WEST SUSSEX COUNTY COUNCIL CONSULTATION

TO:	Arun District Council FAO:Simon Davis
FROM:	WSCC - Highways Authority
DATE:	25 November 2020
LOCATION:	The Former Ship Inn Aldwick Street Aldwick PO21 3AP
SUBJECT:	AW/318/20/DOC Approval of details reserved by condition imposed under ref AW/197/20/PL relating to Condition No 8 - scheme of pedestrian improvements.
DATE OF SITE VISIT:	n/a
RECOMMENDATION:	More information
S106 CONTRIBUTION TOTAL:	n/a / £ See below for breakdown.

Discharge of condition 8 - scheme of pedestrian improvements

PROJECT
Highway Works
The Ship Inn, Bognor Regis
S278 Agreement Drawing

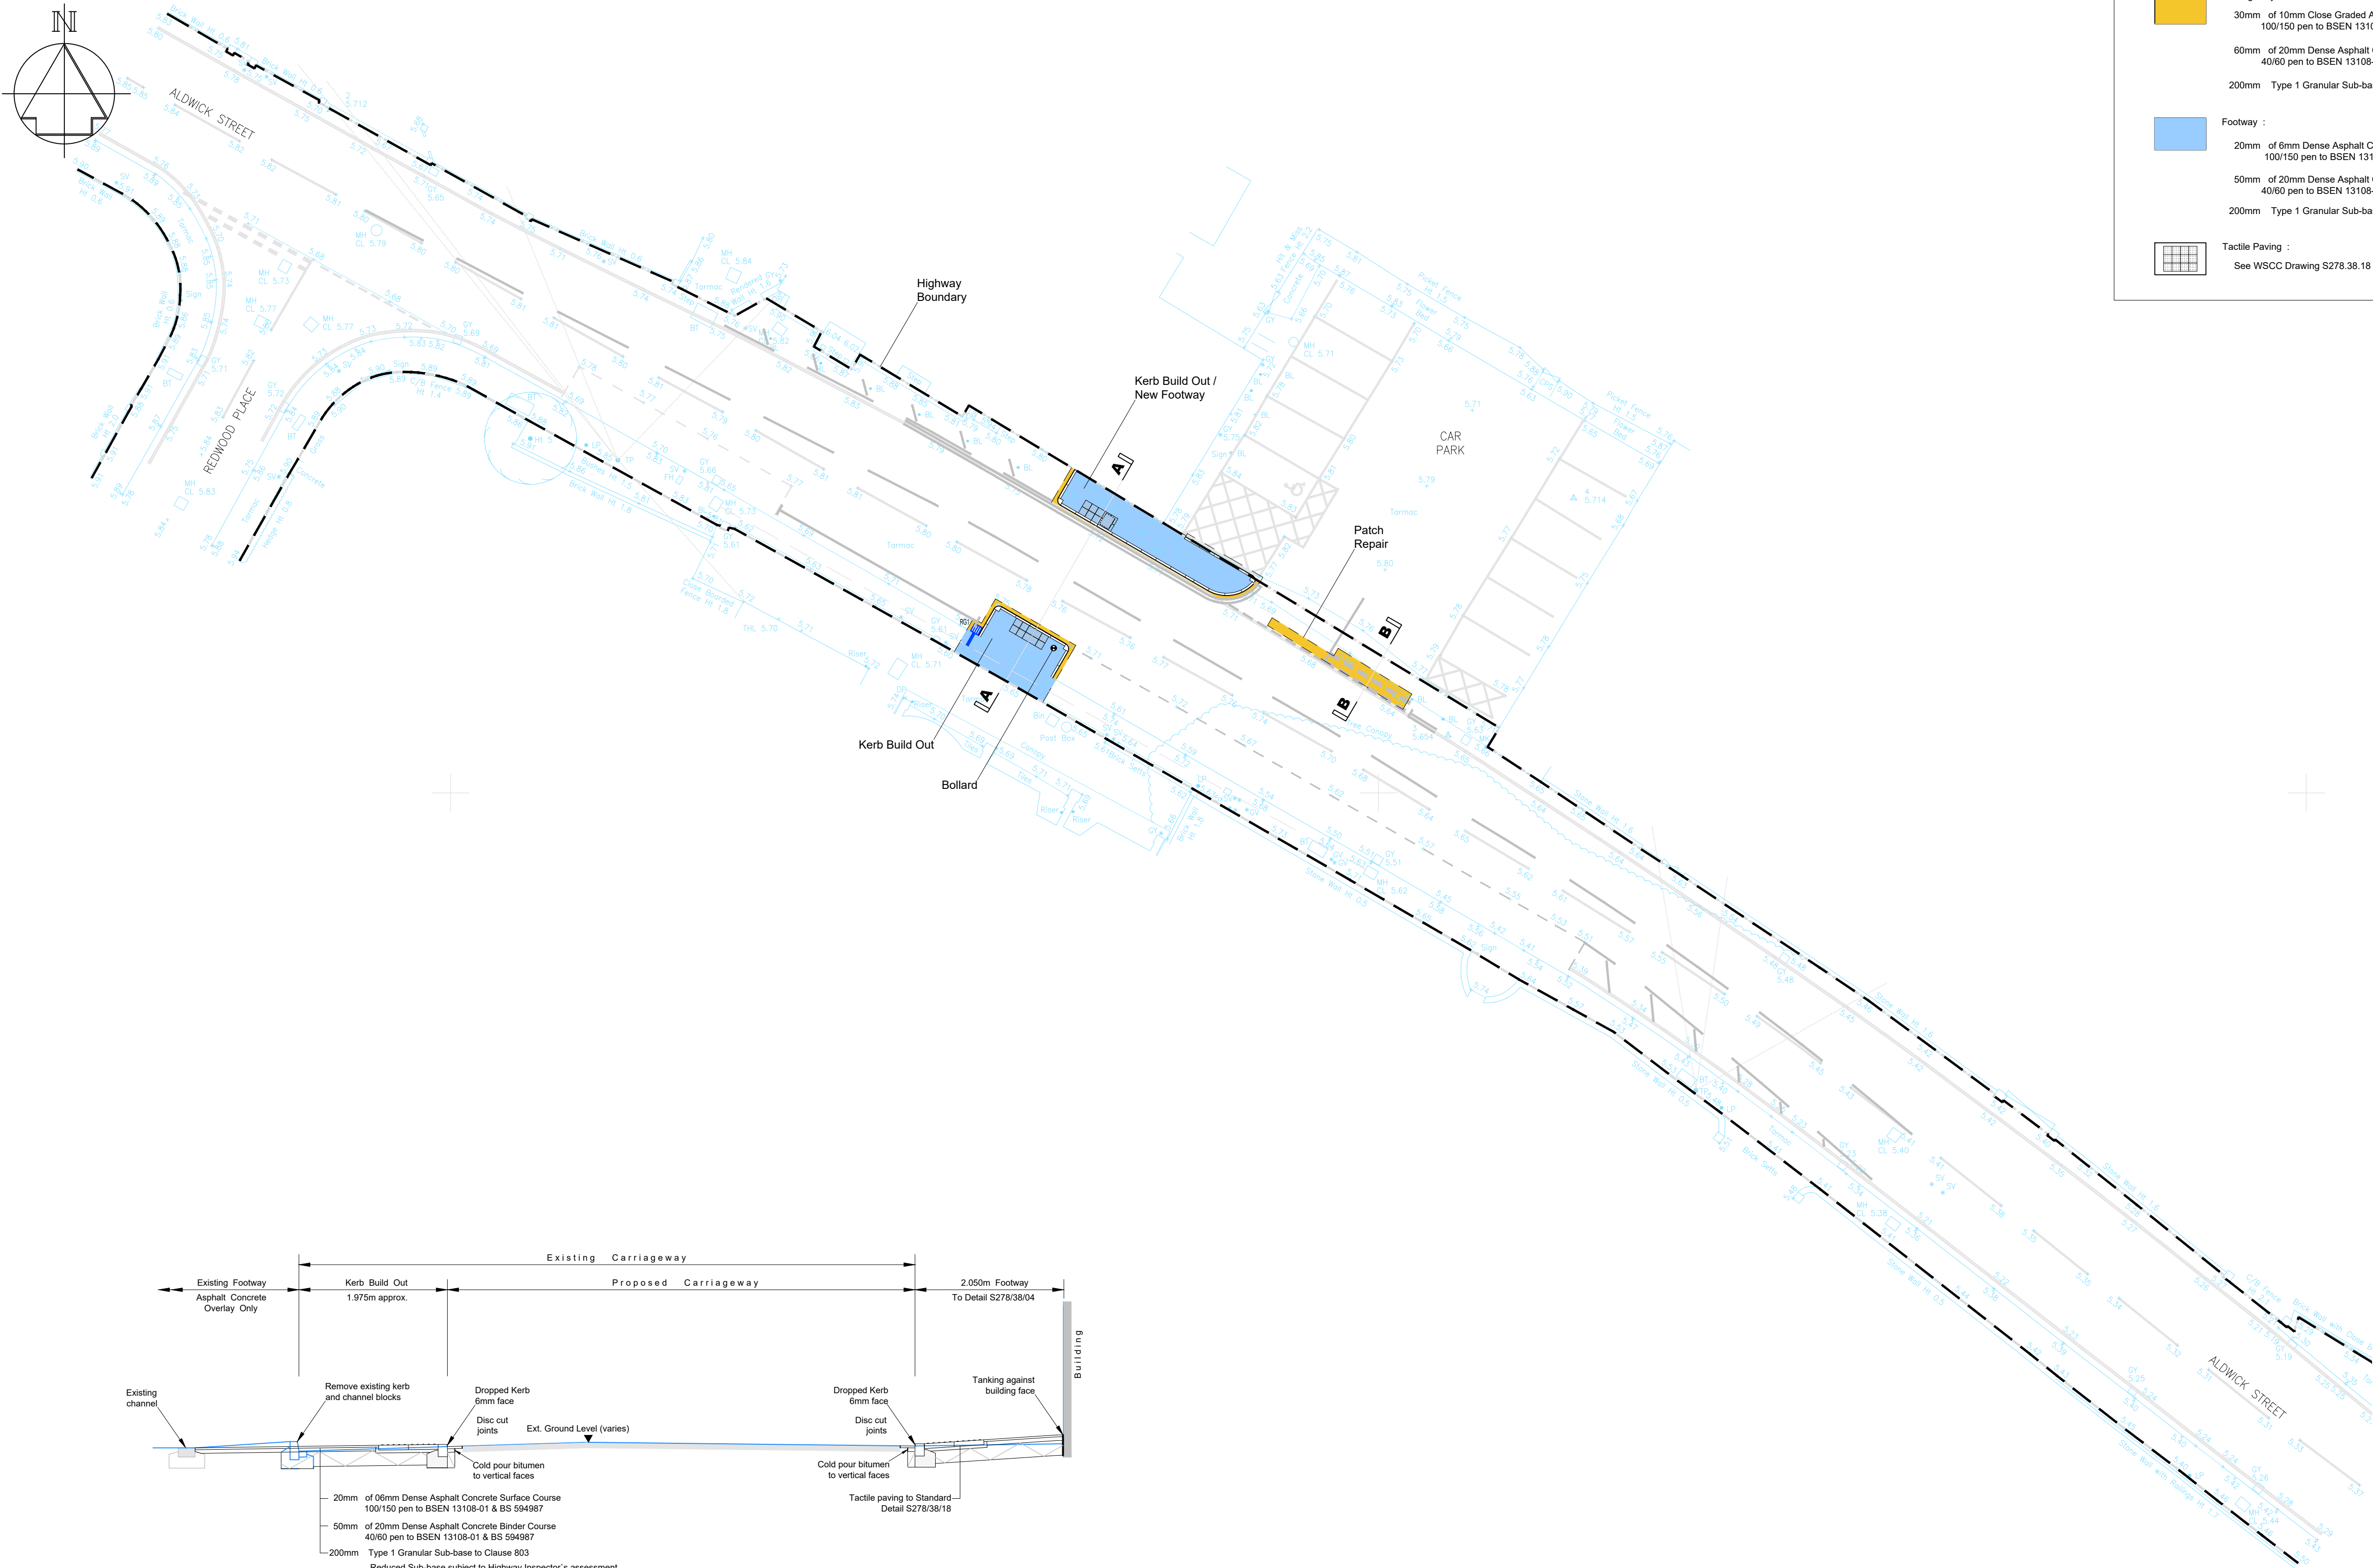
The scheme is currently with our implementation team, and a TRO consultation is currently being progressed. It seems there is some opposition to the TRO, in particular the removal of 1 car parking space to create a build out to assist with crossing the road over to the entrance of the store.

Until the outcome of the TRO is decided i am unable to discharge the condition.
